The Parish Councils of Assington, Bures St Mary, Leavenheath, Little Cornard, Polstead & Stoke by Nayland

Strategic Options, TS Conductor & Impact of Proposed Bramford to Twinstead Reinforcement Works

Response to Applicant's Submissions at Deadlines 8 & 9

Infrastructure Planning (Applications: Prescribed Forms and Procedure) Regulations 2009 Regulation 5(2)(o)

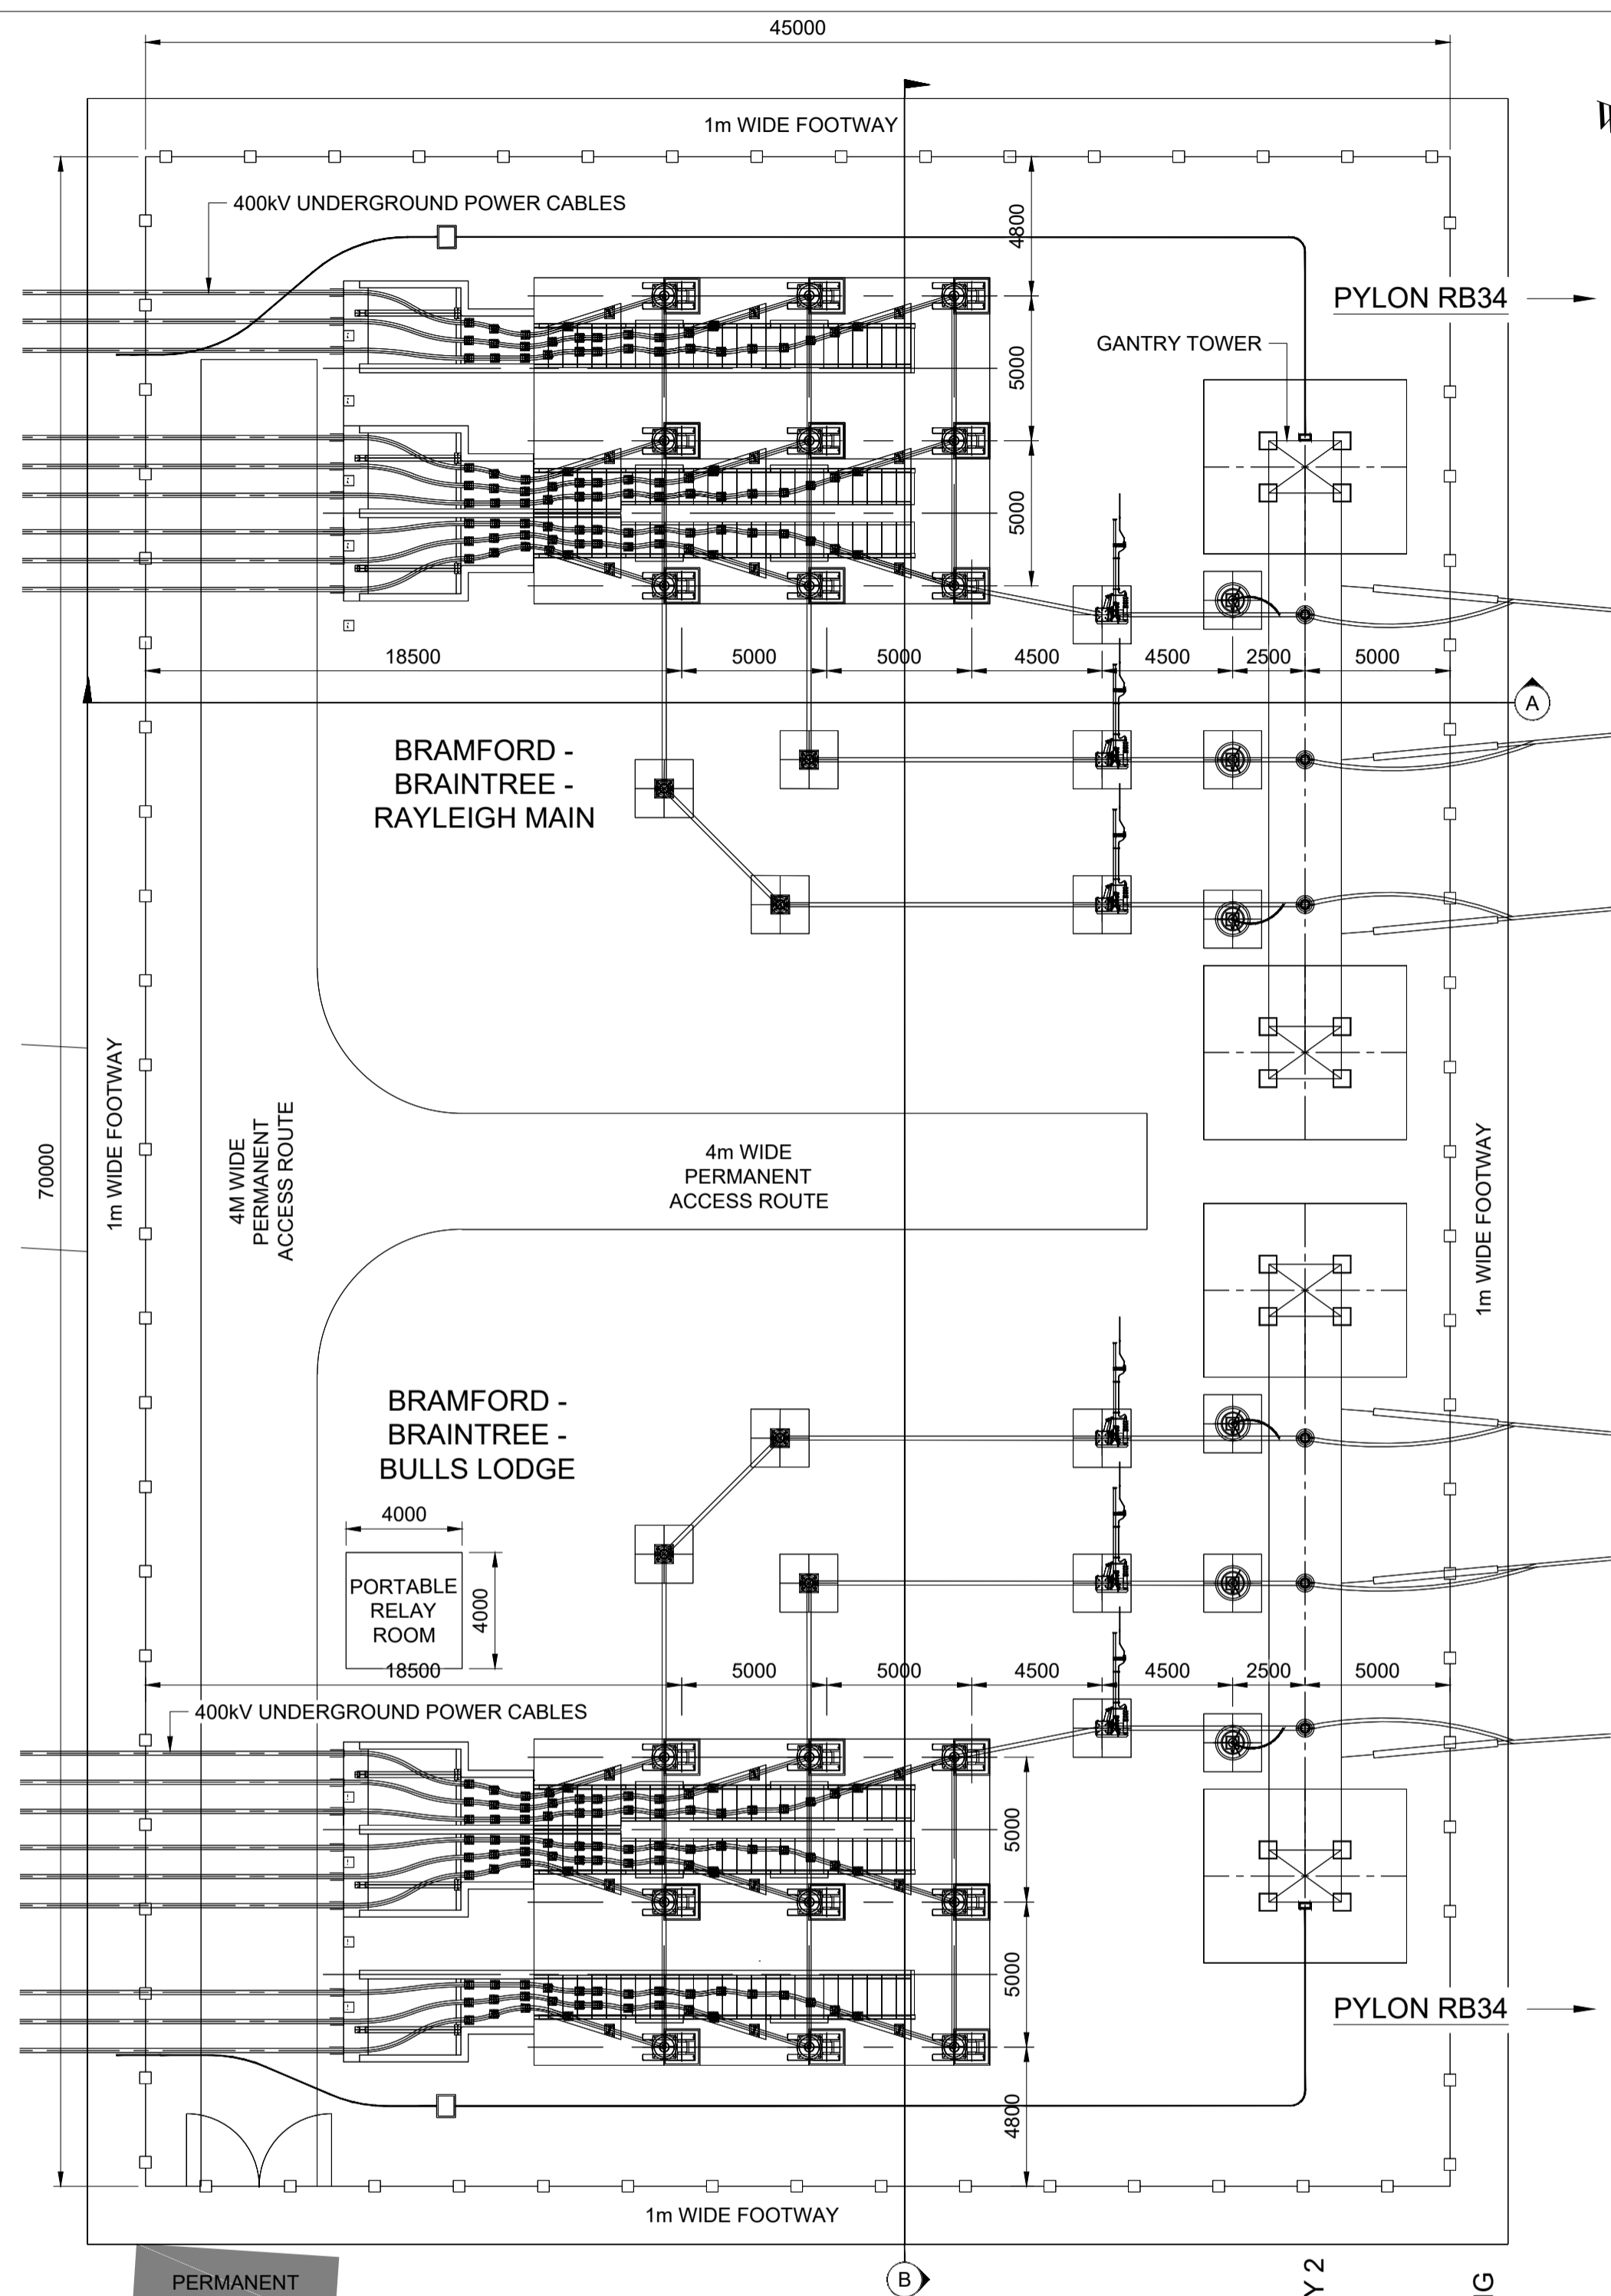
3.2 We completely reject the assertion from the Applicant that *“its proposed site for the Dedham Vale East CSE compound is the most suitable location taking into account all of the relevant factors”*. We are especially concerned over (i) the ranking of the visual impact of the CSE gantries, switchgear and compound below that of the existing 275kV power line that they replace at the Millfield Woods site, and (ii) the assertion that the planting proposals, essentially hedgerow reinforcement, will ameliorate the impacts over time. The communities that we represent consider these arguments on which the Applicant relies to be especially confounding.

3.3 Our aim throughout has been to demonstrate to the ExA the superiority of the quarry alternative on a wide range of practical and environmental grounds. We place our trust in the ExA agreeing that the additional costs associated with the additional undergrounding are more than offset by the benefits secured, and to recommend to the SoS that the compound be relocated into the quarry.
